KIRKLEES METROPOLITAN COUNCIL INVESTMENT & REGENERATION SERVICE

DELEGATED DECISION TO DETERMINE PLANNING APPLICATIONS

Reference No:	2023/62/93305/E
Site Address:	6, Lea Drive, Shepley, Huddersfield, HD8 8HA
Description:	Erection of first floor extension above existing garage, alterations to an existing porch roof, internal and external alterations
Recommending Officer:	Jennifer Booth

DRAWING TITLE
GA DRAWING - PROPOSED

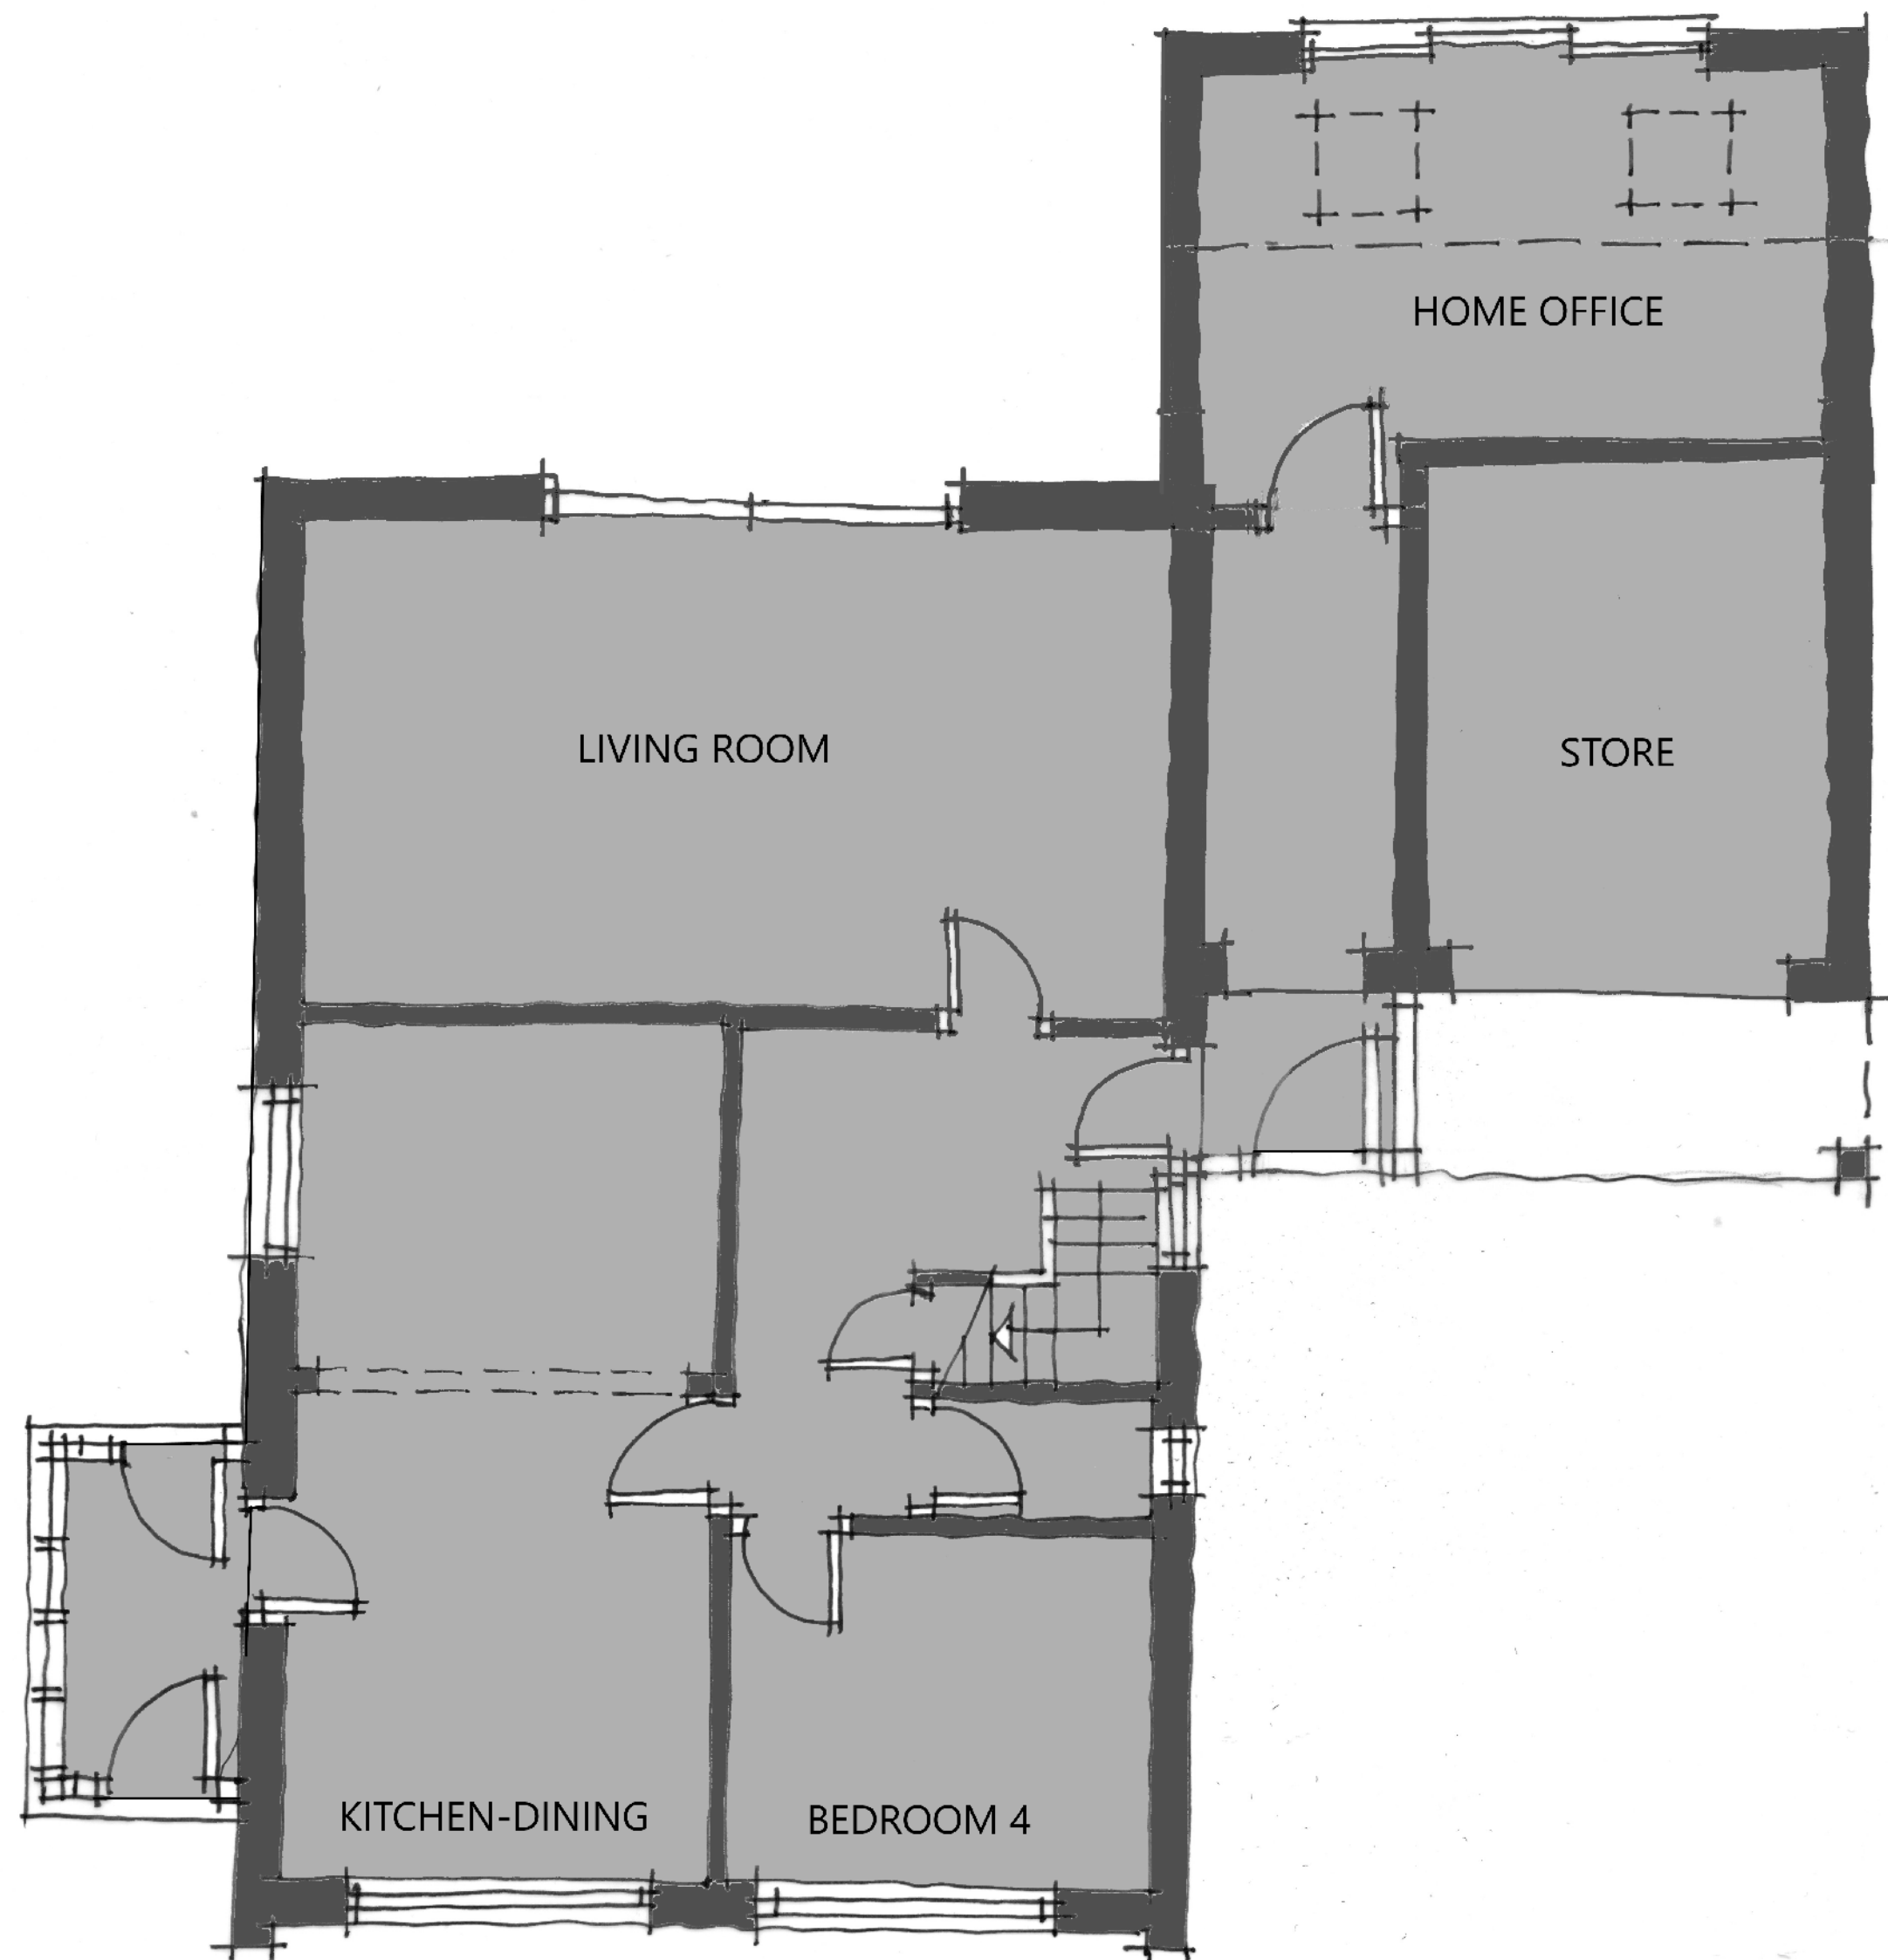
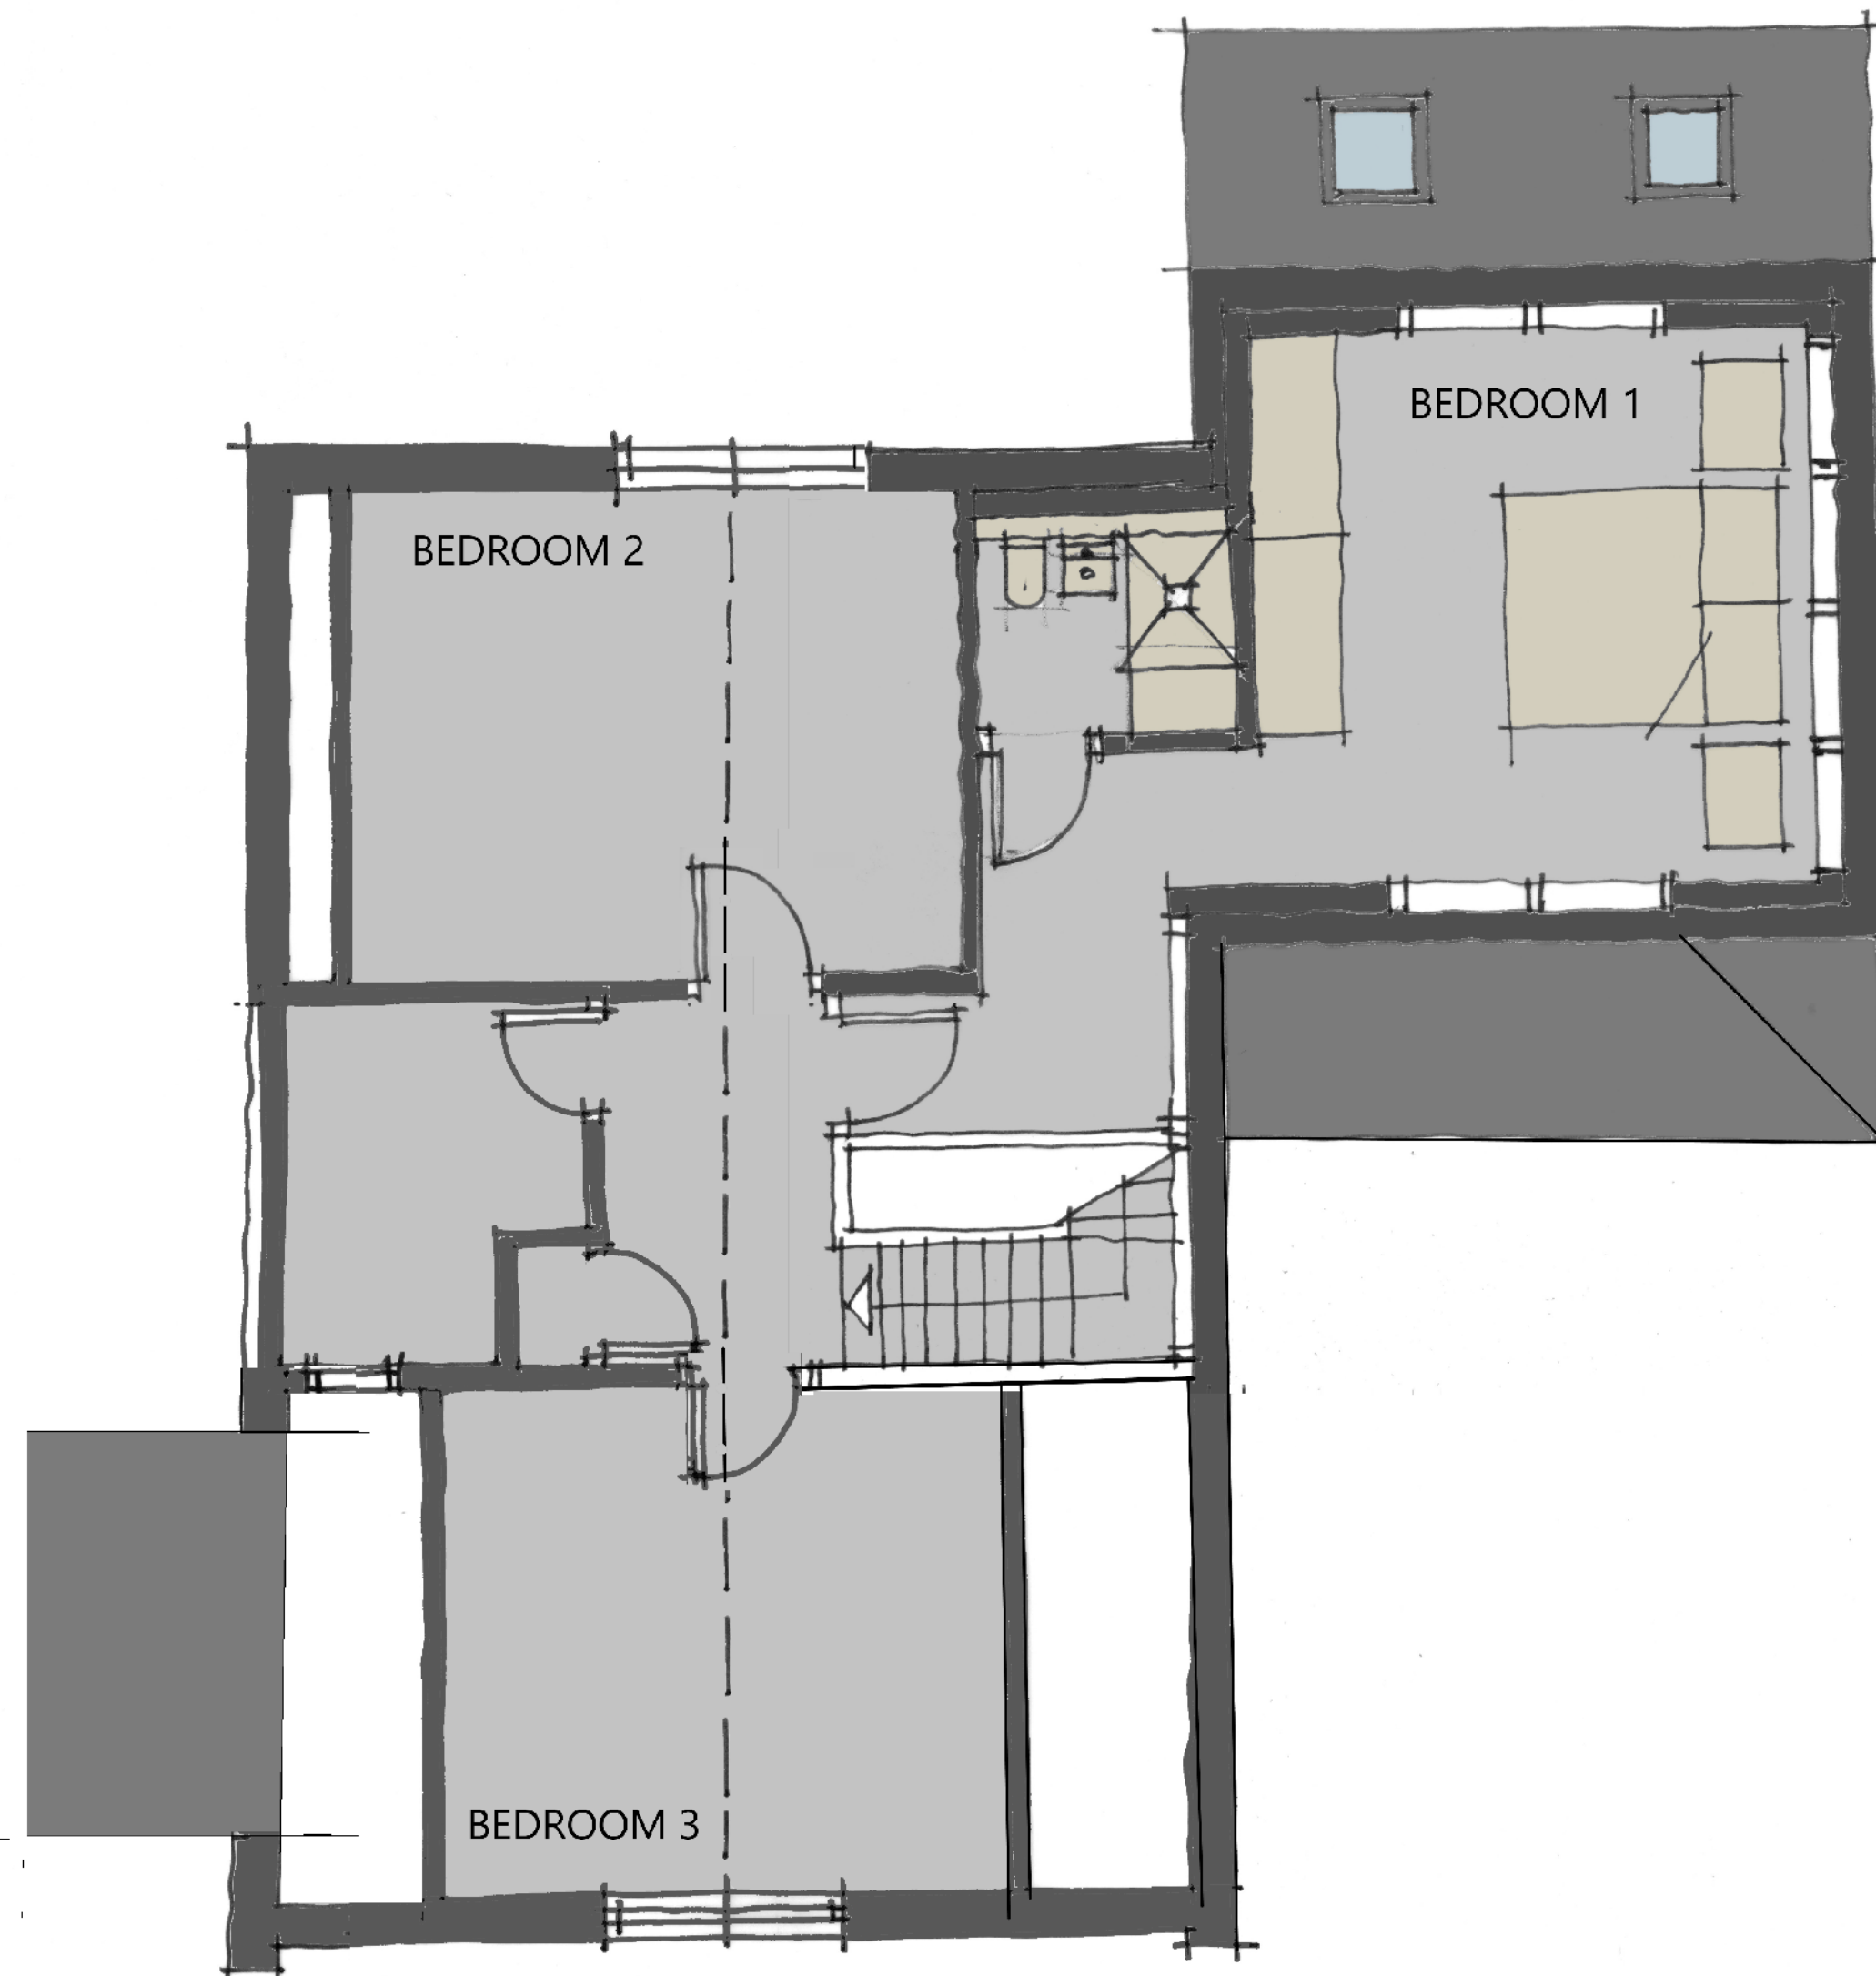
The amended plans include a small canopy at the front of the existing garage. This would be single storey, with less than a 1m projection and open sided for the most part with a small, enclosed porch formed at the junction of the original house and the garage. This would align with the office window. Given the single storey nature, open-sided design and the separation between the properties together with the fencing between, the canopy would have limited impact on the adjacent property.

Furthermore, the alterations to the first floor now include a road facing gable with a roof slope and small dormer which would have limited potential for overshadowing given the position of the property to the north west of the adjacent neighbour or an overbearing impact given this is above the existing garage with a pitched roof sloping away.

The single storey rear element would be set 2.7m from the neighbour's property with a significant boundary treatment between the dwellings and a limited projection of 1.5m. Given the spatial relationship, there would be no overshadowing or overbearing.

The windows in the original house which face the adjacent property serve a hall and landing, neither of which are considered to be habitable. The "new" porch window would also serve the porch area which is not habitable and would be set at least 7m from the neighbour's office window. The front facing gable window would have views down the applicant's own driveway towards the road with no potential to overlook the neighbour's ground floor windows. The dormer windows proposed would serve the new bedroom in a secondary capacity and at a high level, looking towards the neighbour's blank gable and at a height which would not be able to have any views into the two windows in the side elevation of the neighbouring property. The new gable window on

the rear elevation would look straight into the applicant's own garden area and any views towards the neighbour's garden would be at an angle. As such, Officers are satisfied that there would be no undue loss of privacy as a result of the works proposed.

- Loss of light to the neighbour's windows – **Response:** *this is a material consideration as it relates to residential amenity. Whilst this has been addressed within the relevant section of the report, it should be noted that amended plans have been sought and received which reduced the scale of the extension to minimise the impact on the adjacent neighbour.*

- Overbearing and oppressive impact – **Response:** *this is a material consideration as it relates to residential amenity. Whilst this has been addressed within the relevant section of the report, it should be noted that amended plans have been sought and received which reduced the scale of the extension to minimise the impact on the adjacent neighbour.*
